From: Dunderdale, Chris <Chris.Dunderdale@lancashire.gov.uk>
Sent: 04 August 2016 14:42
To: planning
Subject: 3/2016/0580 - Spout Farm

Thank you for consulting us on the above application. Unfortunately the LLFA is unable to provide you with a substantive response at this time for the following reasons:

PSA Design The Old Bank House 6 Berry Lane, Longridge Preston, PR3 3JA Tel. 01772 786066	Client	Mr & Mrs Lambert	Scale	NTS			Dwg No.	Figure 4		
	Job	Spout Farm, Longridge	Drawn	PJB	Check	GS	Date	05.04.13		
	Title	Existing Site Drainage	Appr	GS	Rev

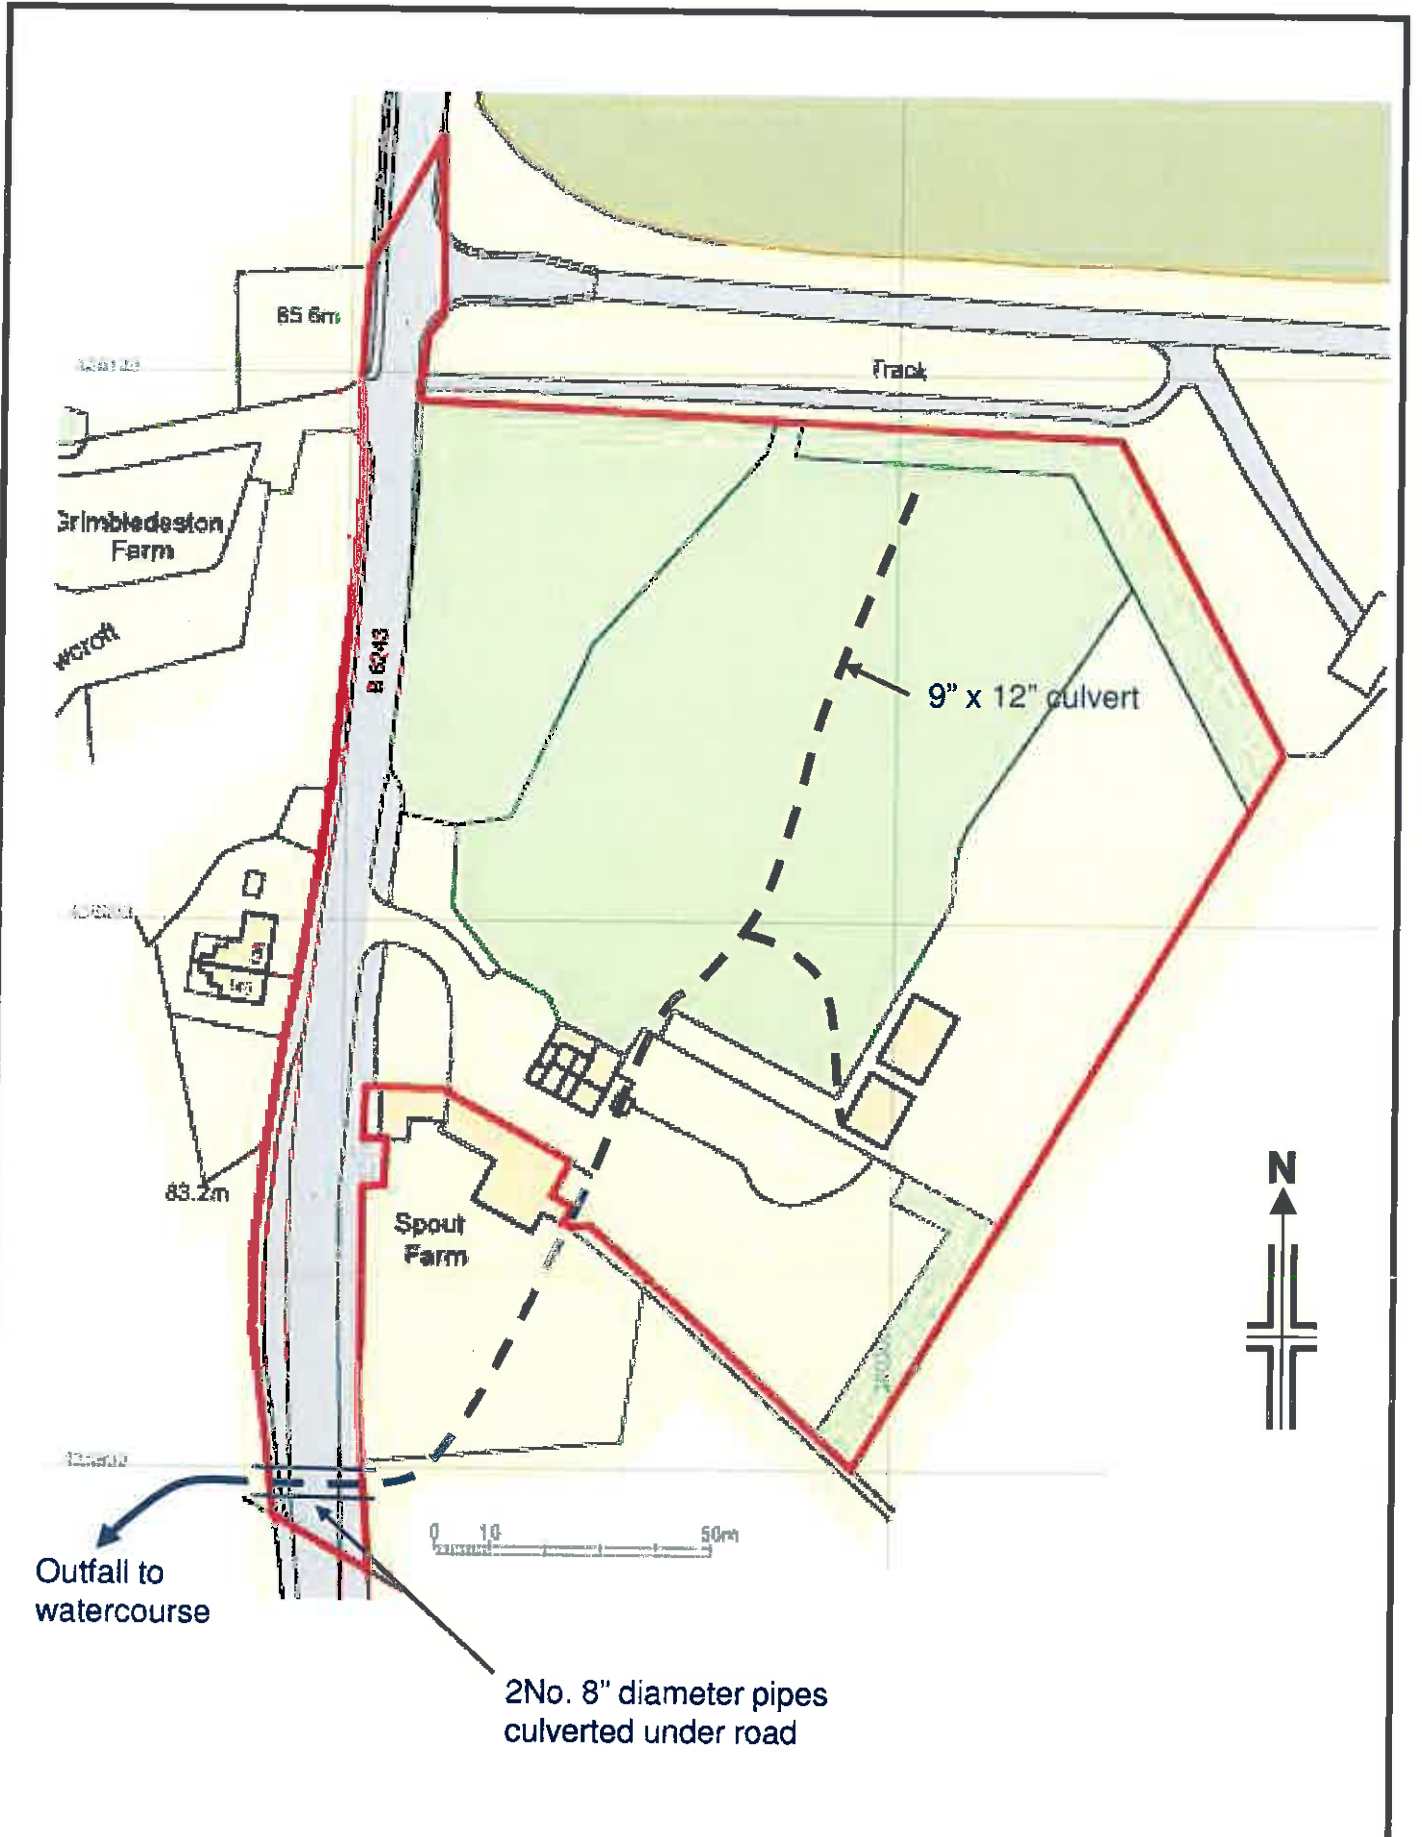
- **Insufficient information regarding the existing culvert that traverses the site:** It is evident from Section 3.2 of the indicative drainage strategy (D1654) that there are a series of existing field drains which collect water from the site. According to the report, these eventually discharge in to an existing 9" x 12" culverted watercourse that appears to run in a south westerly direction through the centre of the site. When comparing this information to the proposed site layout (drawing no. 014 Rev B), it appears as though a number of dwellings are proposed above the line of the existing culvert. The LLFA is concerned by this as building over culverts is considered bad practice as it can restrict future access or replacement. The LLFA would therefore expect for the applicant to clarify/demonstrate that any new development will not be positioned on or within 8m of the existing culvert and should it be necessary, then a scheme to divert the culvert around the new development would be achievable (again maintaining an 8m buffer around the culvert). Please note that the LLFA would also expect for the applicant to consider de-culverting watercourses wherever possible. Please can you discuss this with the applicant and arrange for this to be addressed. If not, then this is likely to result in an objection from the LLFA.

It should be noted that works to divert an ordinary watercourse would require land drainage consent and therefore, we would encourage the applicant to discuss this with the Flood Risk Management Team prior to submitting any further information. This is to ensure that any proposed scheme would be considered acceptable from a land drainage consent perspective. Further information on this can be found via the following link: <http://www.lancashire.gov.uk/roads-parking-and-travel/roads/flooding/alterations-to-a-watercourse.aspx>

It is also noted from Section 3 of the indicative drainage strategy that an extensive and intrusive site survey of the existing drainage network was undertaken by the client prior to the report being prepared in August 2013. As it has been more than 12 months since the network was surveyed, it is likely that a further survey will be required in order to establish the current condition of the culvert. Subject to the findings of further investigations, the feasibility of discharging surface water to the culvert may be subject to appropriate mitigation measures and/or an appropriate legal agreement.

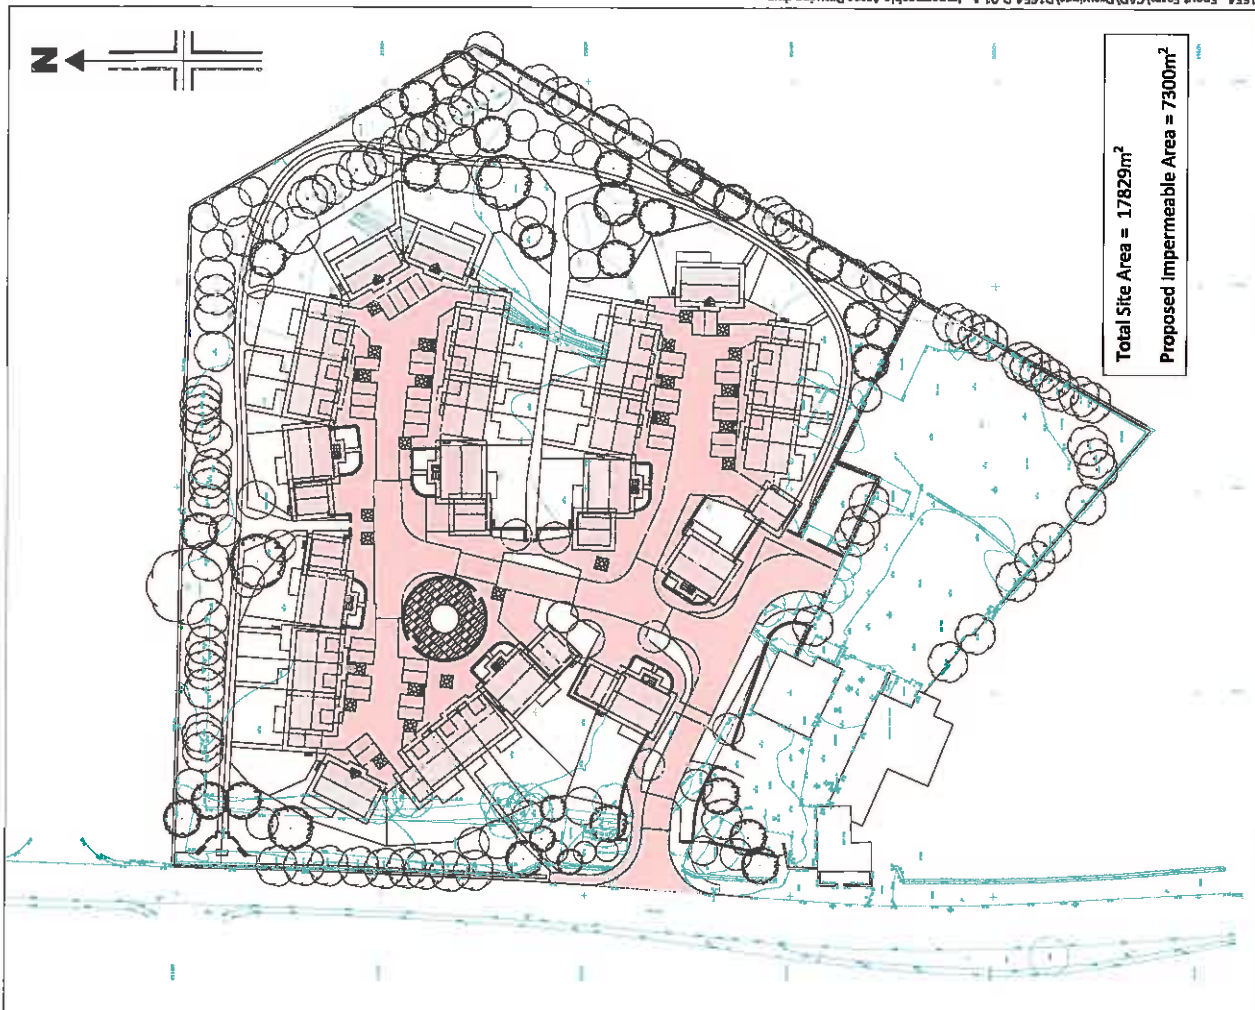
- **Clarification required over the use of porous paving:** It is evident from the FRA that the applicant intends to use porous paving on all driveways and paths. Whilst this is

encouraging to see, the LLFA would like to remind the applicant that the use of porous paving must not be included as part of the hydrological calculations for the site. The reason for this is that occupants may change driveways to non-permeable materials in the future and therefore, this has the potential to increase surface water runoff which was previously unaccounted for in the design of the sustainable drainage system. Please can you discuss this with the applicant and arrange for it to be clarified whether or not the use of porous paving has been included within the hydrological calculations provided within the FRA.
